# Rezoning Transportation Analysis

Petition Number: #2022-111

**From: Jake Carpenter, PE**  
Jacob.carpenter@charlottenc.gov  
980-221-5675

Date	Description
11-28-22	First Review (PDM)

RZ.01

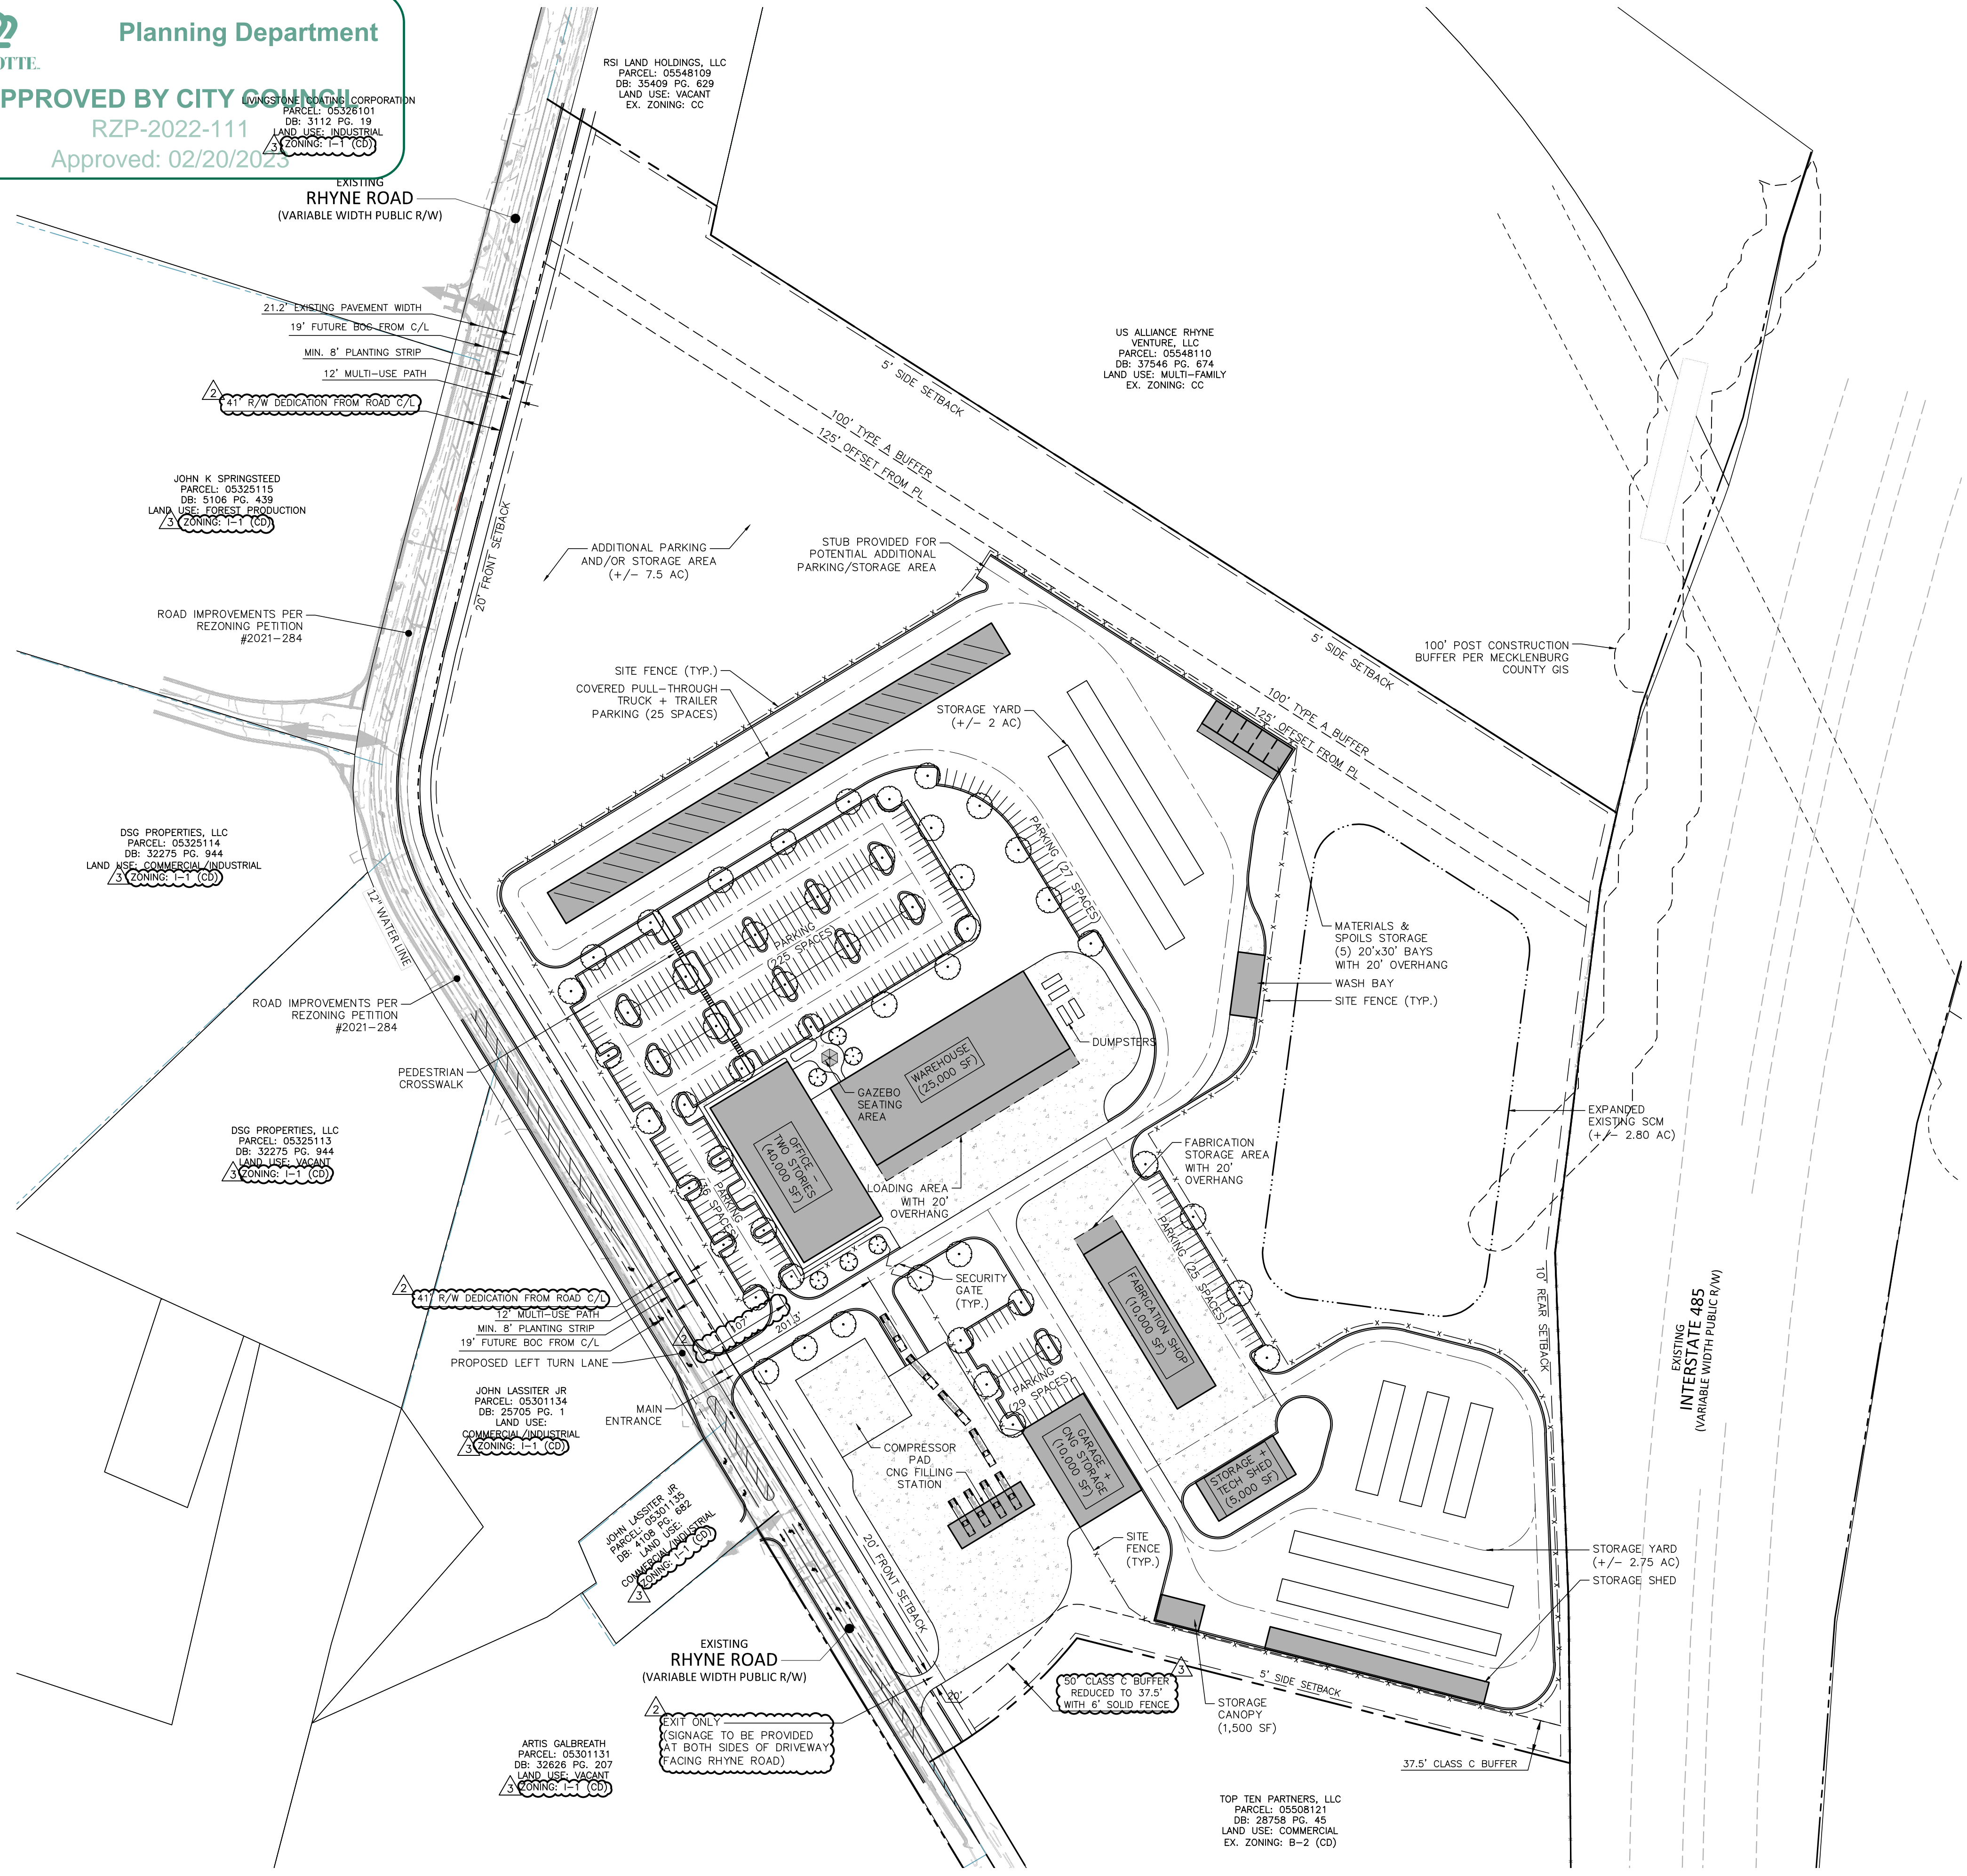
- a. **Rhyne Road:** Location of curb and gutter shall be placed 19-feet from the existing centerline to the back of curb.

Label and dimension the curb and gutter from the centerline.

3. Revise site plan and conditional note(s) to commit to dedicate 41-feet of right-of-way, along the site's frontage of Rhyne Road, from the road centerline. The site plan shall label and dimension the right-of-way from the road centerline.

4. Revise site plan and conditional note(s) to commit to construct an 8-foot planting strip, and 12-foot shared-use path along the site's frontage of Rhyne Road. The site plan shall label and dimension each item from the back of curb. Clearly show the shared-use path on the site plan.

5. Per coordination with NCDOT turn lanes will be required at the Rhyne Road proposed accesses. Confirm turn lane requirements with NCDOT or provide a three-lane cross section on Rhyne Road across the entire property frontage.

6. Per coordination with NCDOT, revise site plan and conditional note(s) to consolidate the proposed access points for the site. All access points on Rhyne Road will need a minimum of 100-feet of protected storage and a turnaround should be provided for gated driveways. In addition, add

conditional note that all driveways must meet intersection sight distance requirements to receive a driveway permit.
